**KIRKLEES METROPOLITAN COUNCIL
INVESTMENT & REGENERATION SERVICE**

**DELEGATED DECISION FOR DISCHARGE OF CONDITION A.4 -
NOTIFICATION OF A PROPOSED ENLARGEMENT TO DWELLINGHOUSE**

Reference no.	2026/HH/90038/E
Site Address	20, Water Royd Lane, Mirfield, WF14 9SF
Description	The proposal is for erection of single storey rear extension. The extension projects 4m beyond the rear wall of the original dwellinghouse. The maximum height of the extension is 3m, the height of the eaves of the extension is 2.7m
Recommending Officer	Molly Storer

2388/2

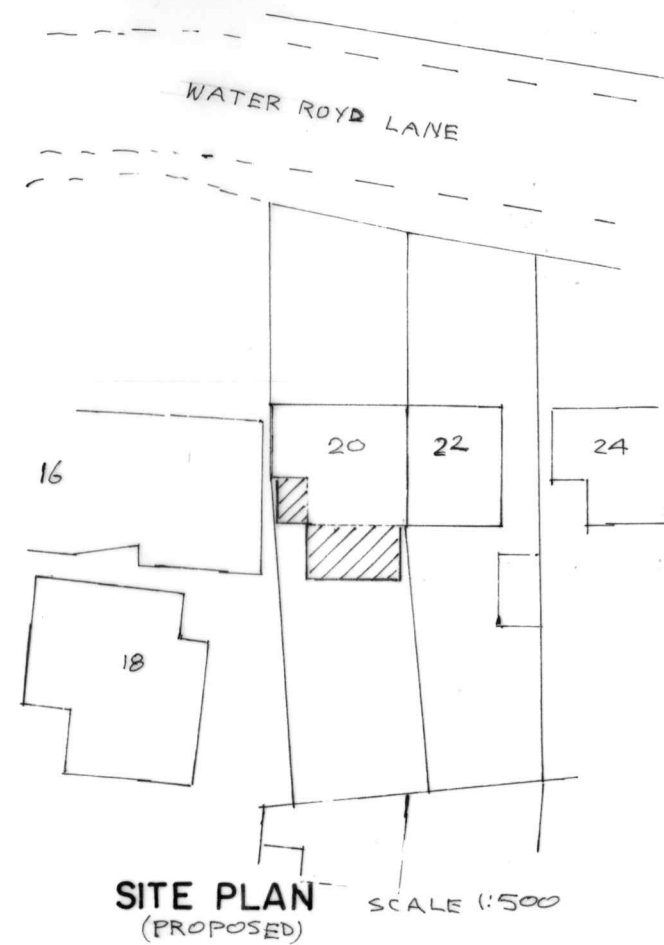
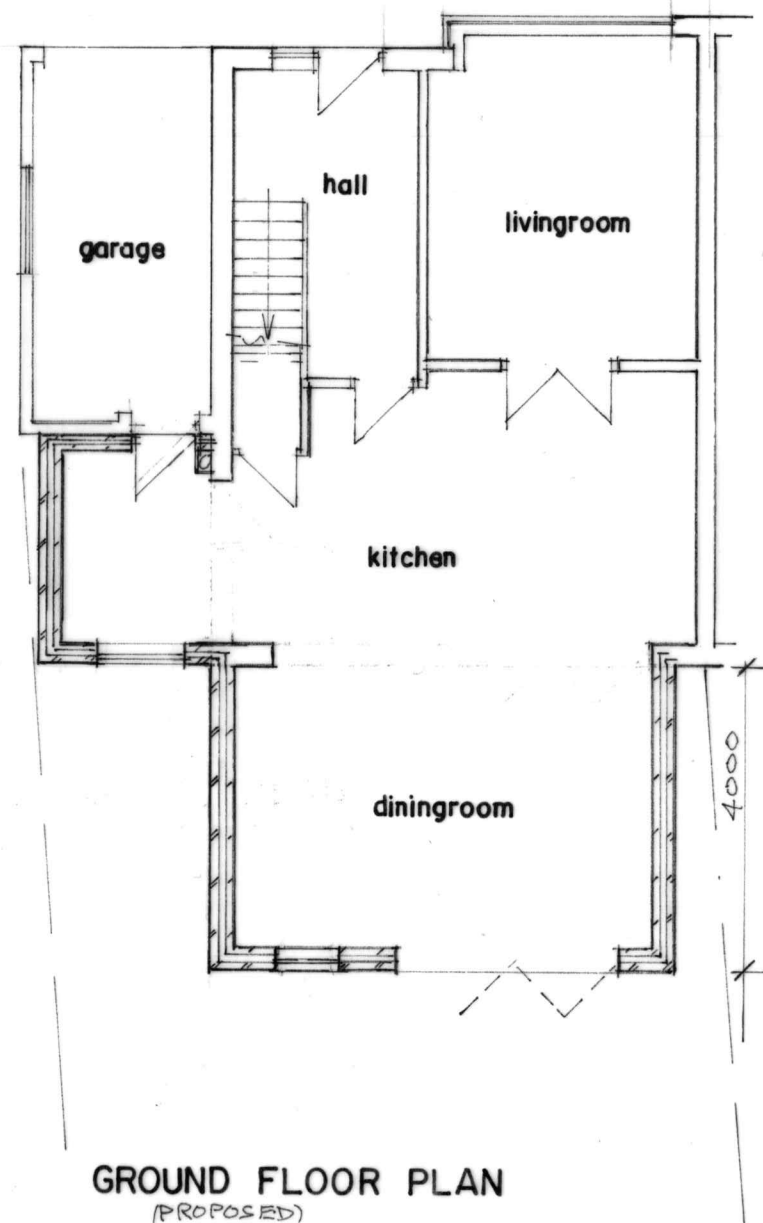
The plans show that there will be two separate enlargements, one projecting from the garage and one projecting from the kitchen. The element from the garage will extend 3m and from the kitchen it will extend 4m.

The element extending from the kitchen is considered to be the rear wall of the original dwellinghouse. However the garage is also considered to be original from looking at aerial and historical imagery. Therefore, both element would project from the rear wall of the original dwellinghouse although it is only the 4 metre projection that would benefit from Class A, paragraph A.4.
